**KIRKLEES METROPOLITAN COUNCIL
INVESTMENT & REGENERATION SERVICE**

Reference No:	2024/62/91277/E
Site Address:	3, Field Head, Shepley, Huddersfield, HD8 8DR
Description:	Erection of two storey side and single storey rear extensions with associated alterations
Recommending Officer:	Edward Cheseldine

HOUSEHOLDER DELEGATED REPORT

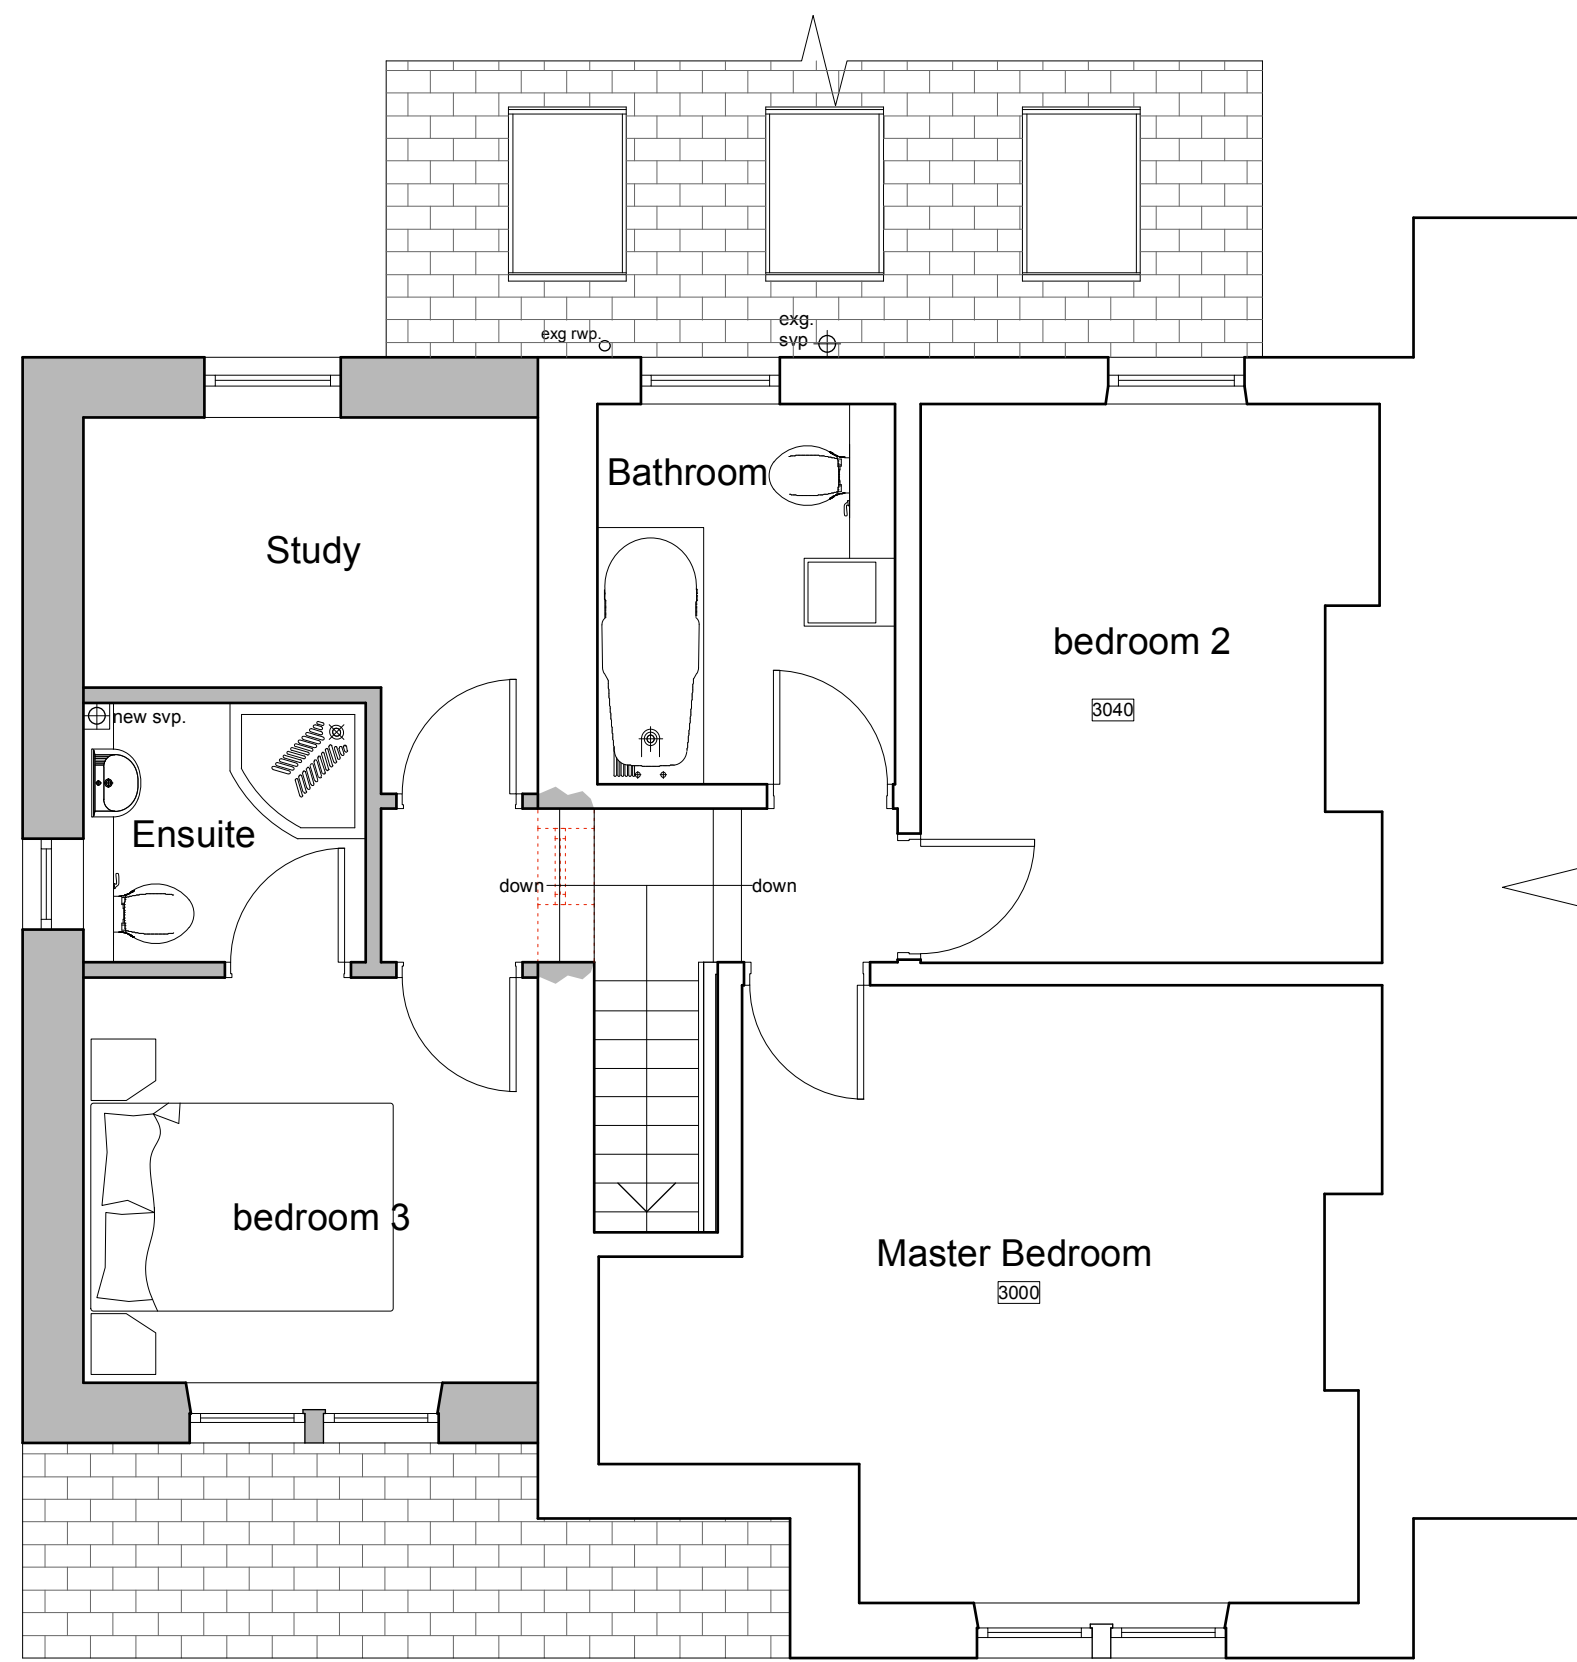
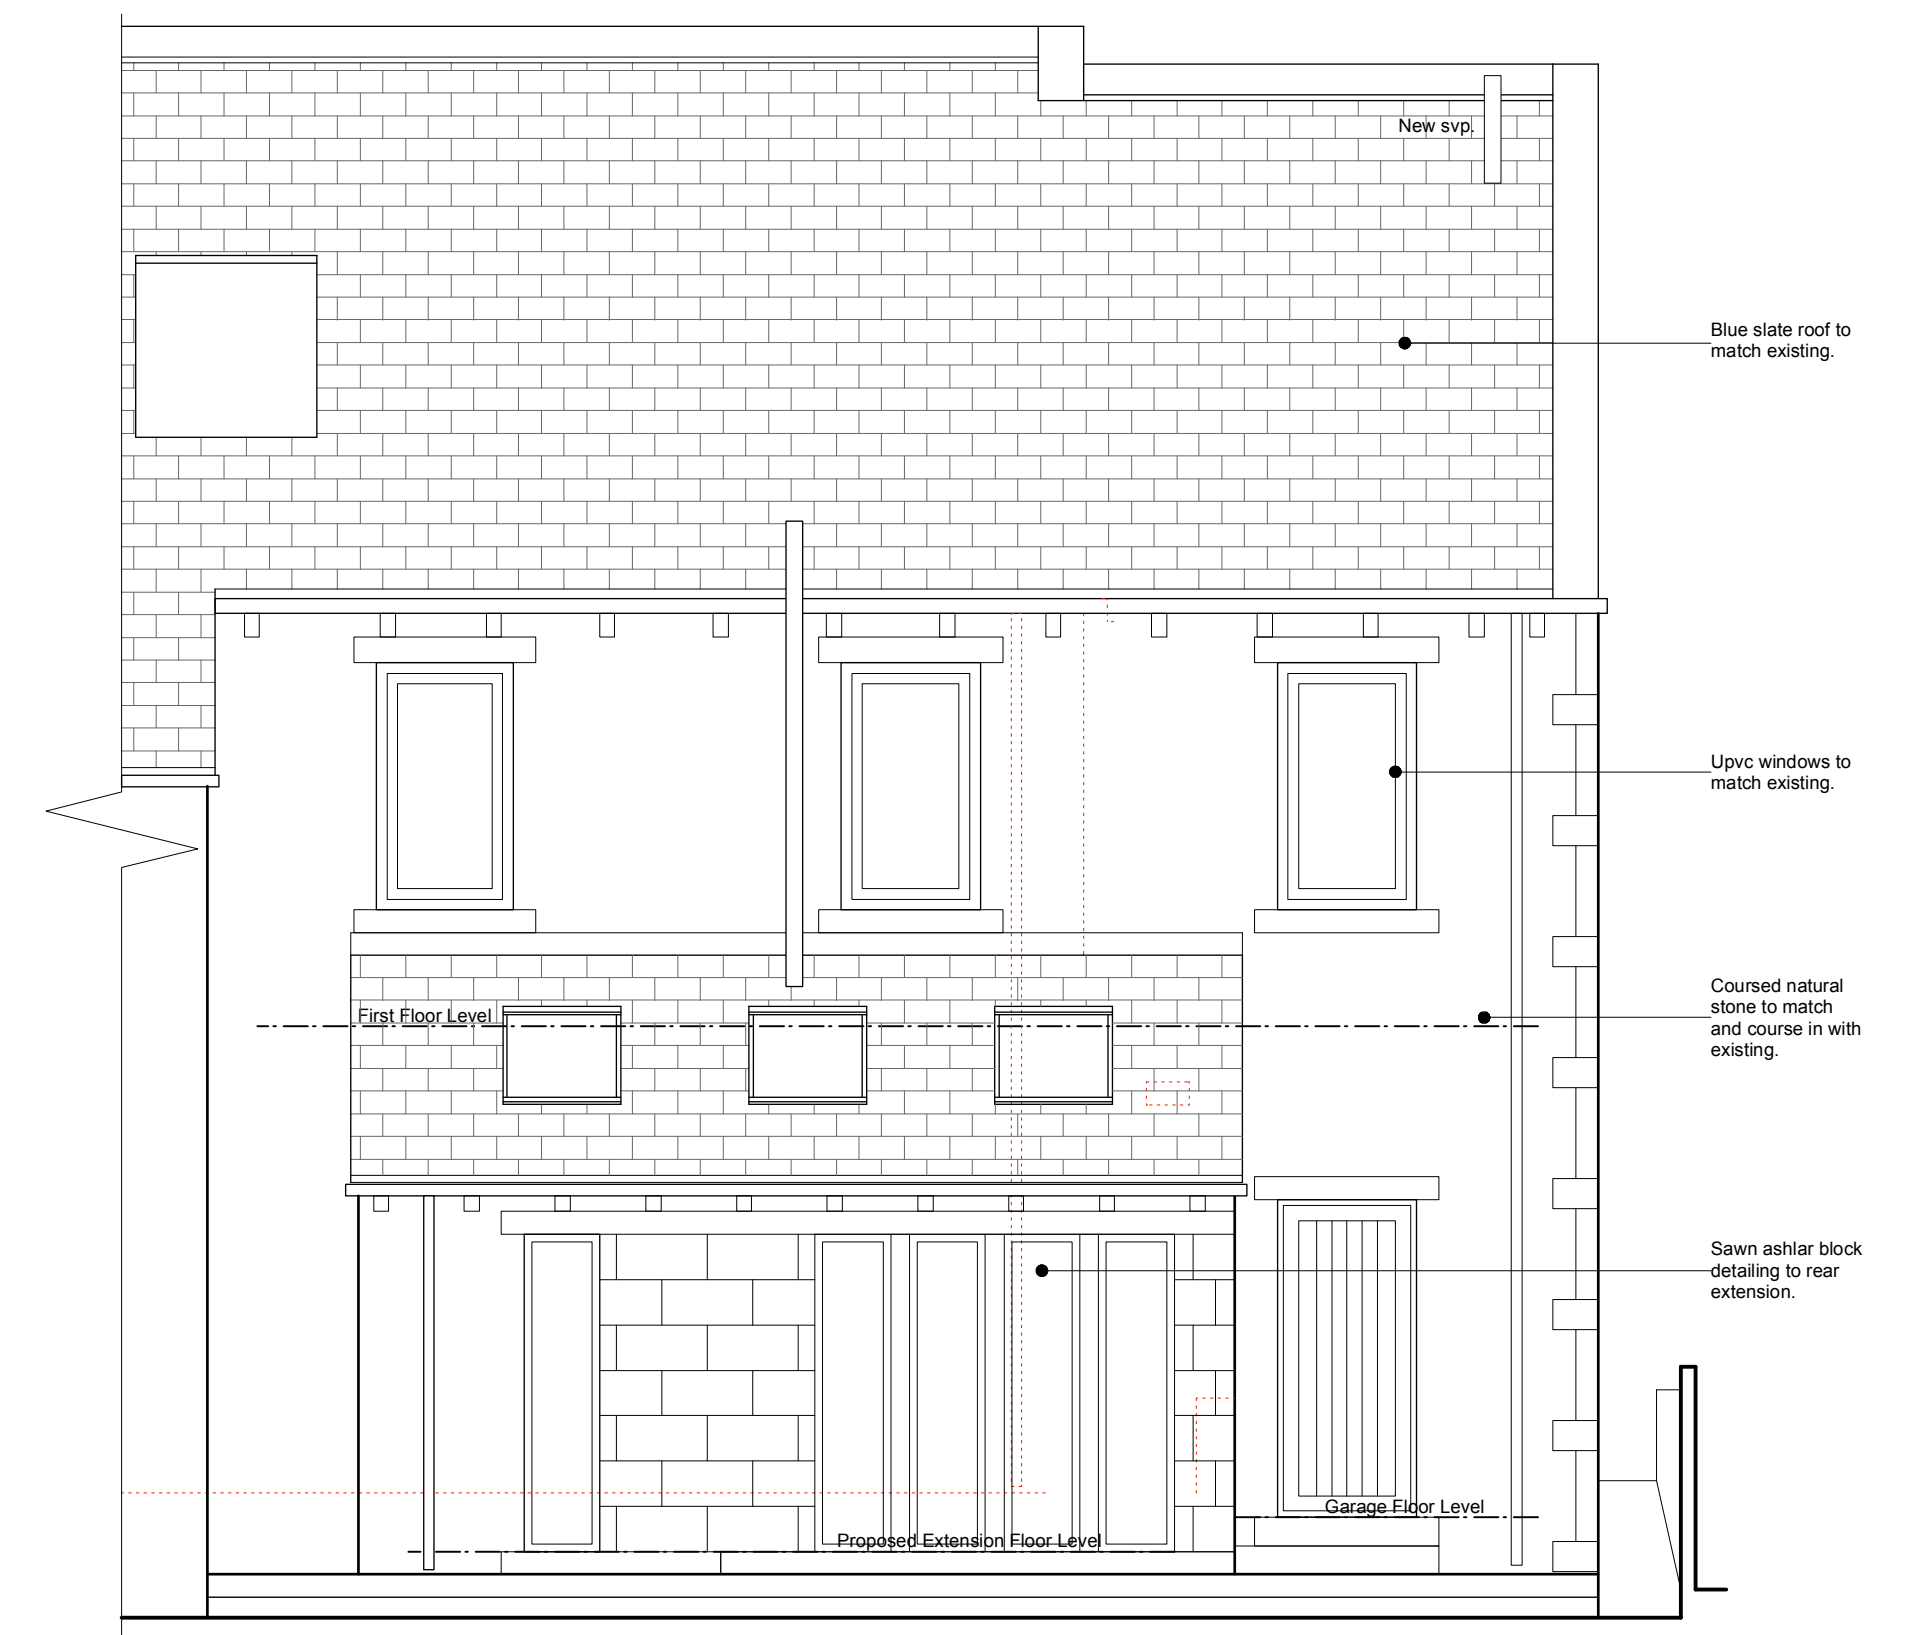
YES / NO	SUMMARY
Negotiations/Amendments during course of application		Yes, request for amended plans or to justify as per paragraph 1.11 of the House Extensions and Alterations Supplementary Planning Document as the plans did not accord to guidance set out in the design codes document. Amendments: Rear extension set in by ~1.00m to allow for 45oC

angle of outlook for neighbouring property. Side extension set back by ~0.50m. Ridgeline of side extension set down by ~0.35m. Justification for spacing to the side of the property: ~0.5m retained. Internal space required for garage. Rear door added to allow for access to the rear.
Parish/Town Council comments sought	Kirkburton Parish Council	No comment.
Relevant Planning History		<u>Application site</u> – None <u>1 Field Head</u> - 2021/93277 – Single-storey rear extension – Full permission granted
Consultations required	None

Amendments: Rear extension set in by ~1.00m to allow for 45oC angle of outlook for neighbouring property.

Side extension set back by ~0.50m.

Ridgeline of side extension set down by ~0.35m.
